CITY OF ALBUQUERQUE

Re: Barlow Shop
6205 Wilshire Ave NE
Traffic Circulation Layout
Engineer's/Architect's Stamp 12-11-19 (C18D070)

Based upon the information provided in your submittal received 1-15-19, the above referenced plan cannot be approved for Building Permit until the following comments are addressed:

Site Plan

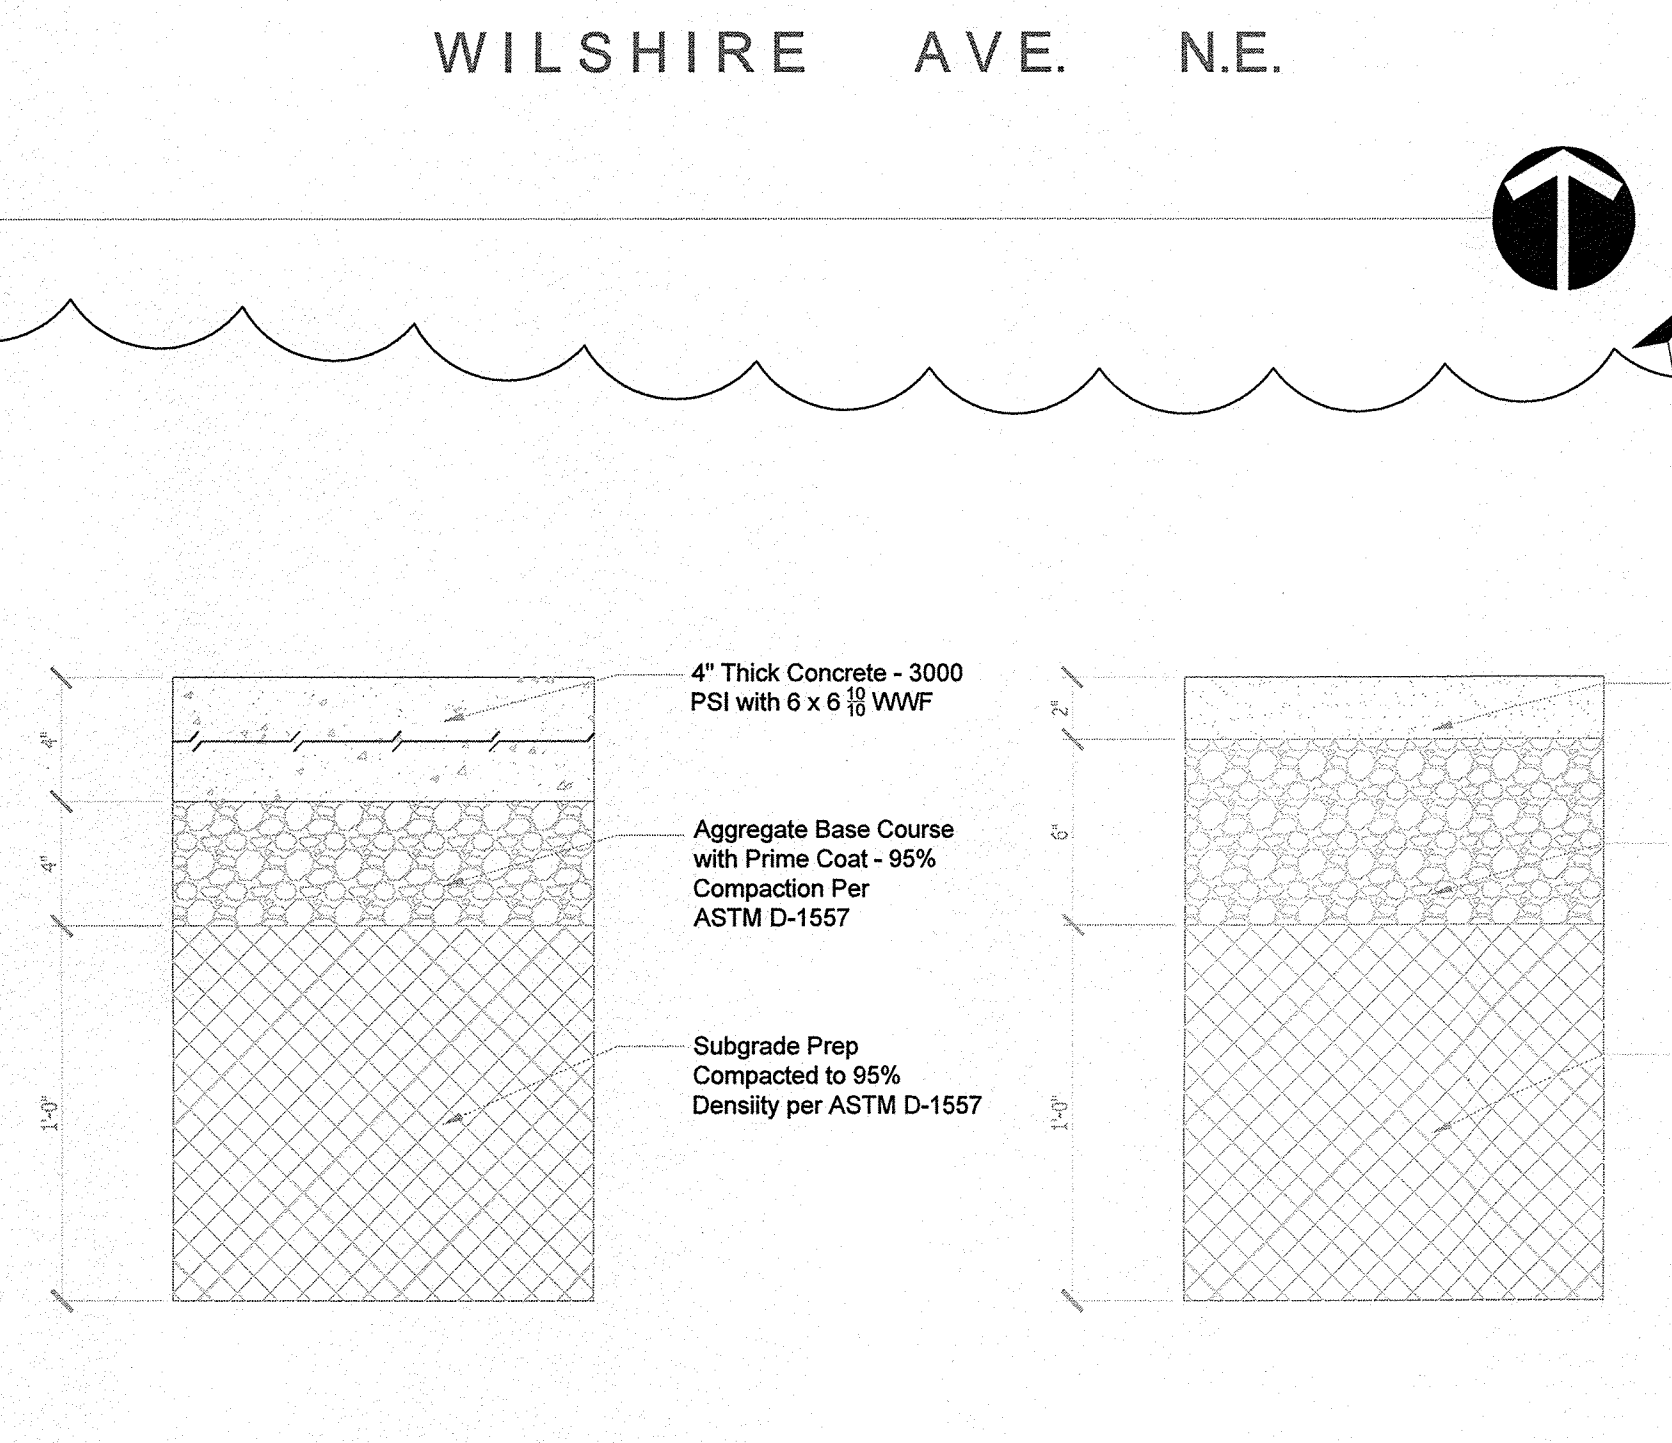
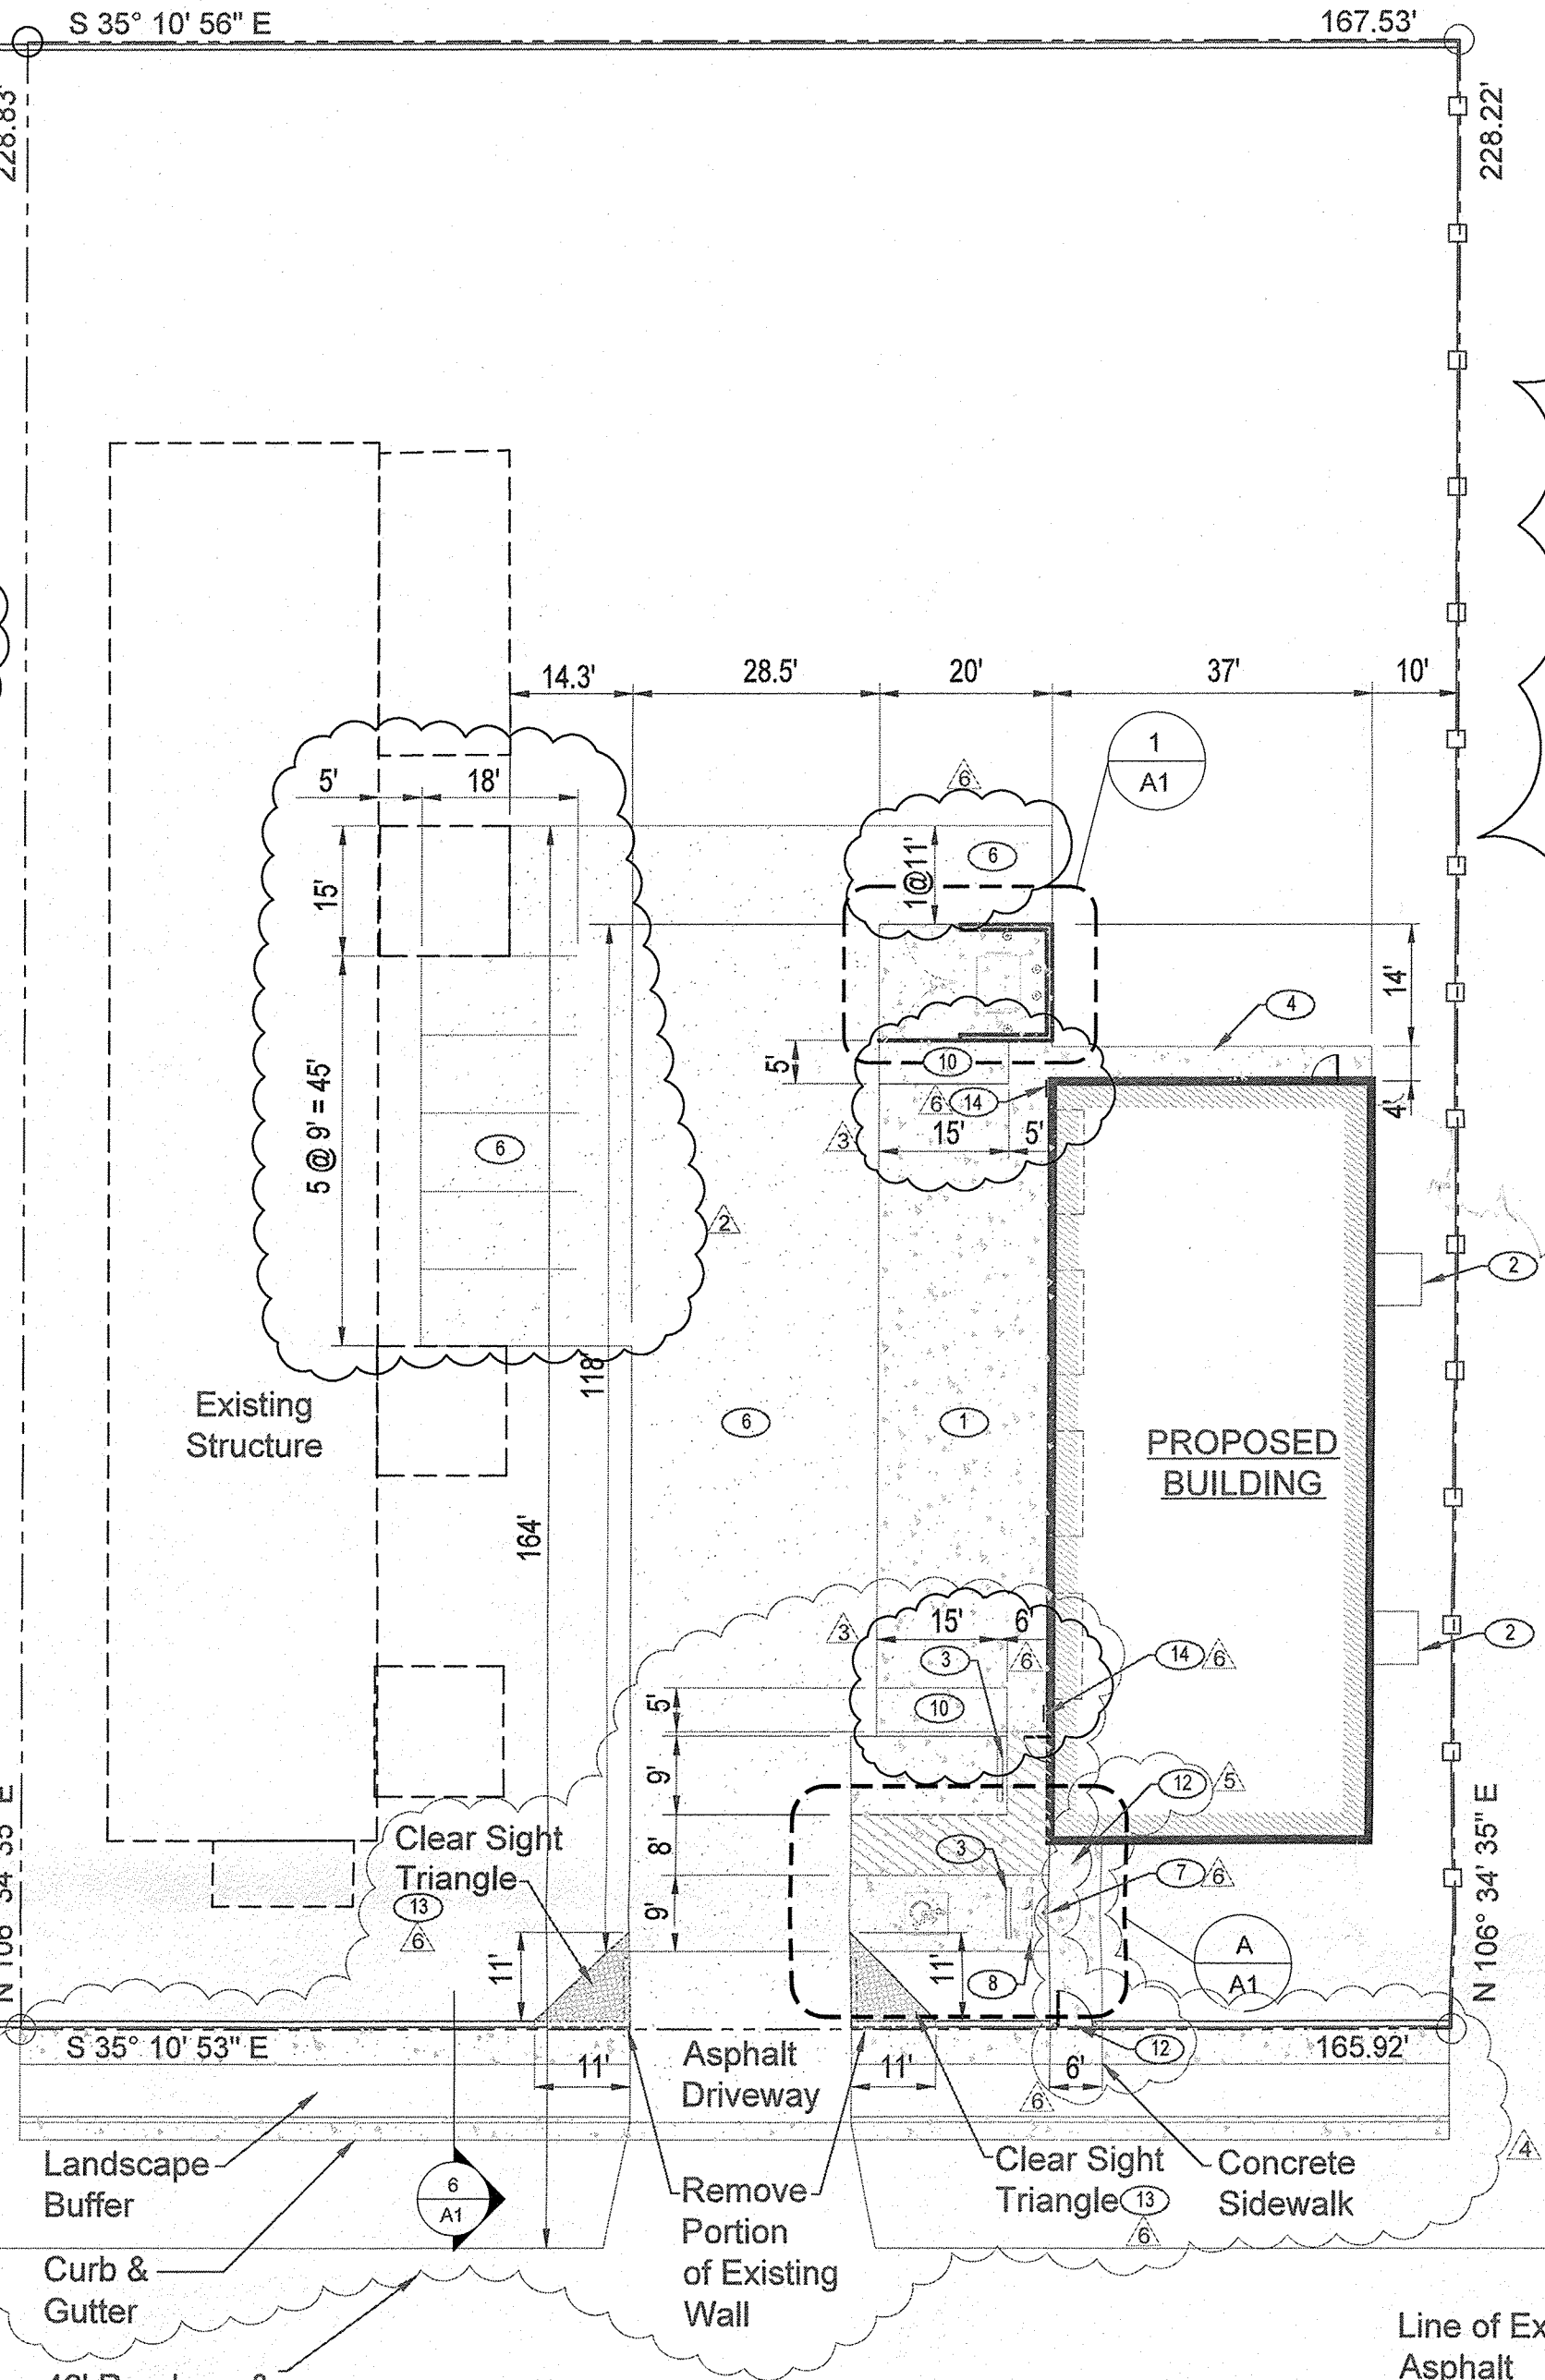
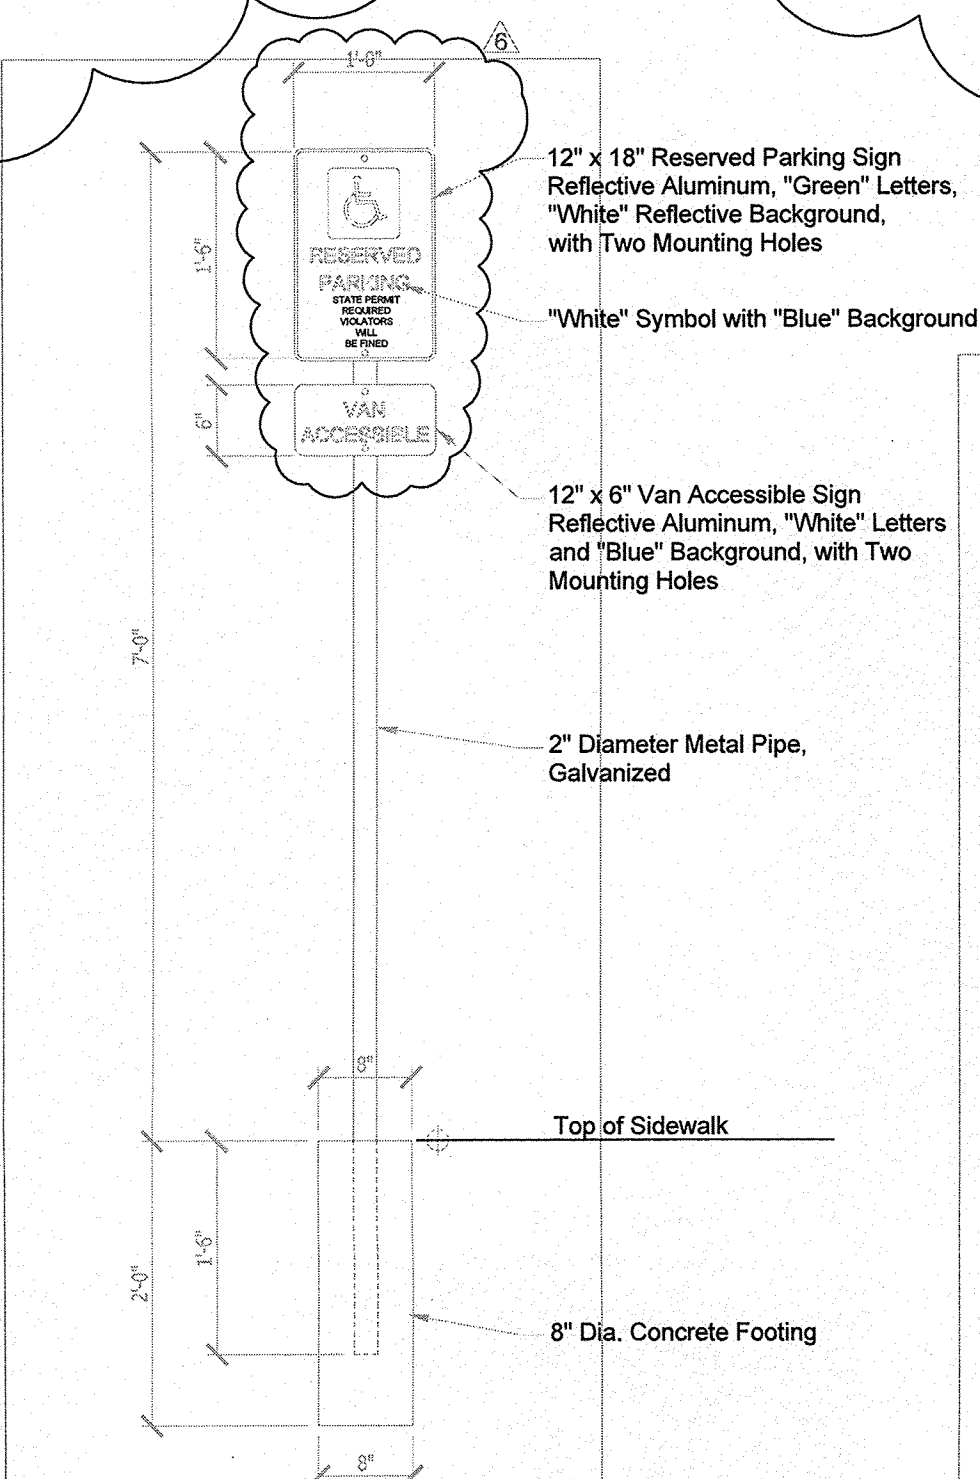
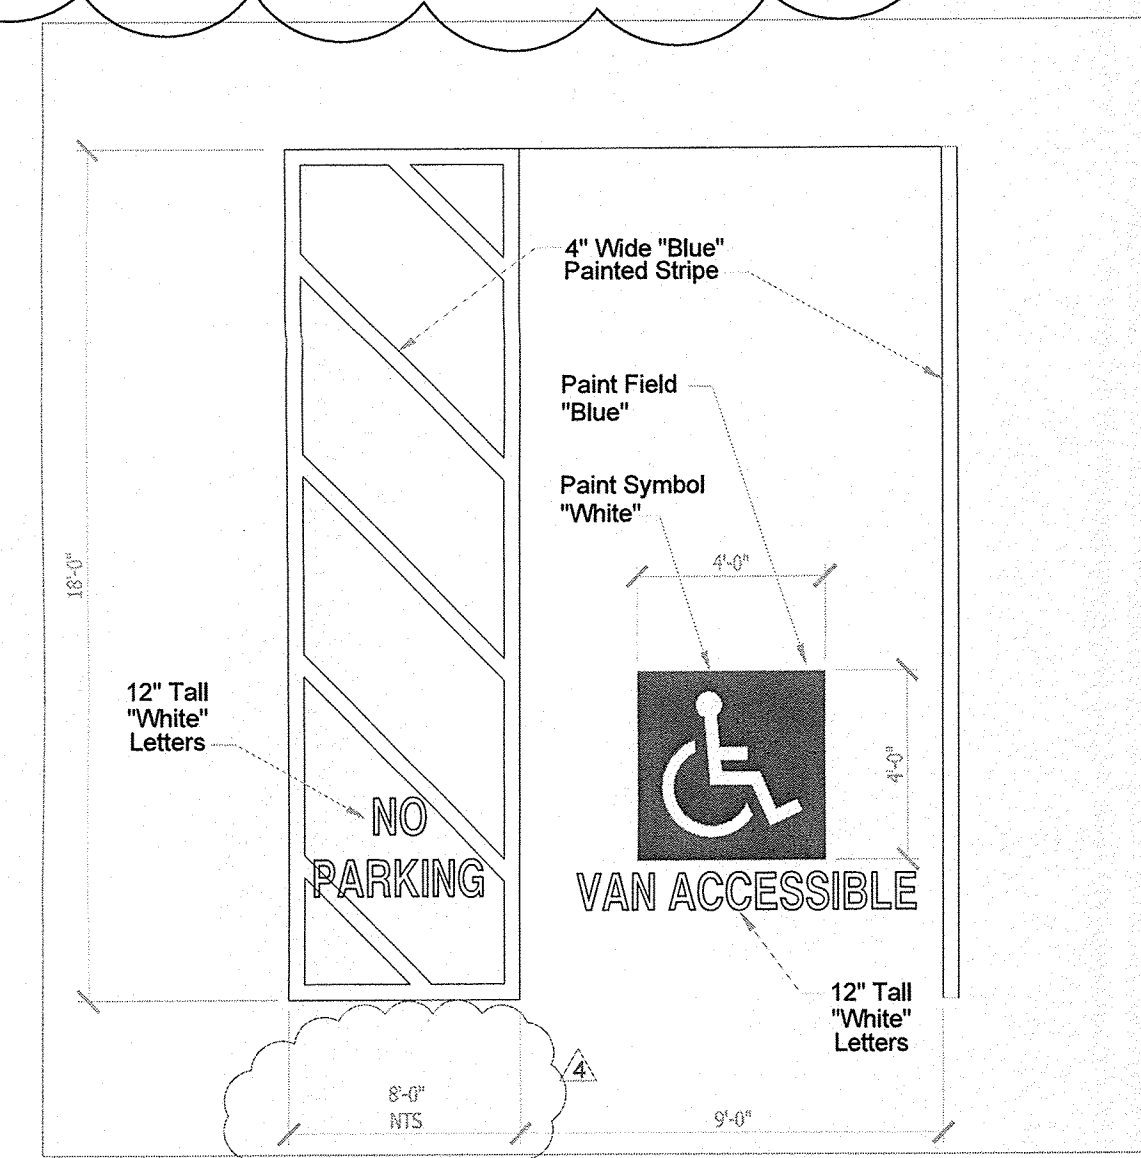
1. List the number of parking spaces required by the IDO as well as the proposed number of parking spaces including bicycle and motorcycle parking.
2. Please call out on TCL location of Bike Rack.

3. The ADA accessible parking sign must have the required language per 66-7-352.4C NMSA 1978 **"Violators Are Subject to a Fine and/or Towing."** Please call out detail and location of HC signs.

4. Each Motorcycle parking space shall be designated by its own conspicuously posted upright sign, either free-standing or wall mounted per the IDO. Please add sign detail.

5. Per the IDO, a 6 ft. wide ADA accessible pedestrian pathway is required from the public sidewalk to the building entrances. Please clearly show this pathway and provide details.

6. Per DPM, a 6 ft. wide ADA accessible pedestrian pathway is required from the HC parking stall access aisles to the building entrances. Please clearly show this pathway and provide details.

7. Service vehicle and/or refuse vehicle maneuvering must be contained on-site; provide a copy of refuse approval.
8. Add the following note to the plan for the Clear Site Tringle: "Landscaping and signage will not interfere with clear sight requirements. Therefore, signs, walls, trees, and shrubbery between 3 and 8 feet tall (as measured from the gutter pan) will not be acceptable in the clear sight triangle."

9. Please specify the City Standard Drawing Number when applicable. Please add Sidewalk City Standard #2430, Curb and Gutter City Standard #2415 & Drive Access City Standard #2425 and add detail for ADA compliance.
10. Please add Truncated domes to ramps located in the Public Right of Way.
11. Provide notes showing what work is included and on the work order and the private work on site.
12. Please add a note on the plan stating "All improvements located in the Right of Way must be included on the work order."
13. Please indicate transition from ADA access aisle to building entrance.
14. Please include one copy of the traffic circulation layout at the next submittal.
